10 April 2013

Reference: P\13\13 – 45 Kings Drive, Pagham. PO21 4PZ

PROPOSED FRONT ELEVATION 1:100

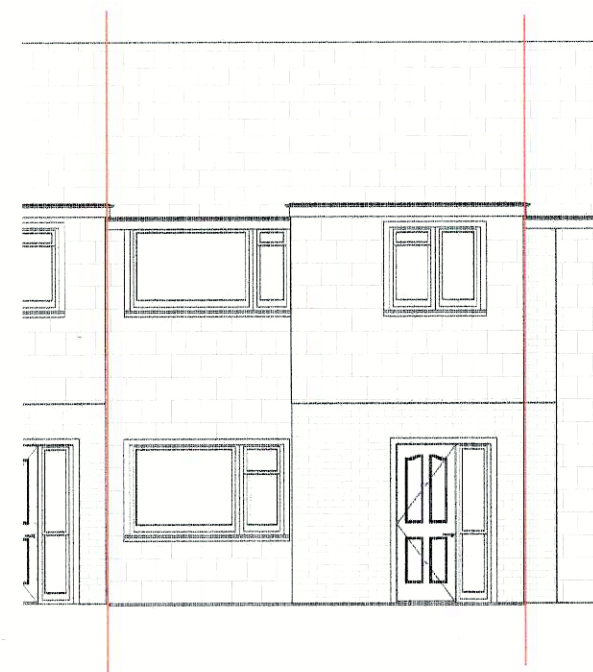
We are writing to voice our concerns regarding the above planning application, not we hasten to add to the rear extension. Our concern is relating to the proposed second storey extension to the front porch which we feel is totally inappropriate, and, if allowed to be carried out could create a precedence which would spoil the planned design of the fifteen terraced houses with open plan frontages. It may also cause loss of light and higher noise levels to adjoining properties.
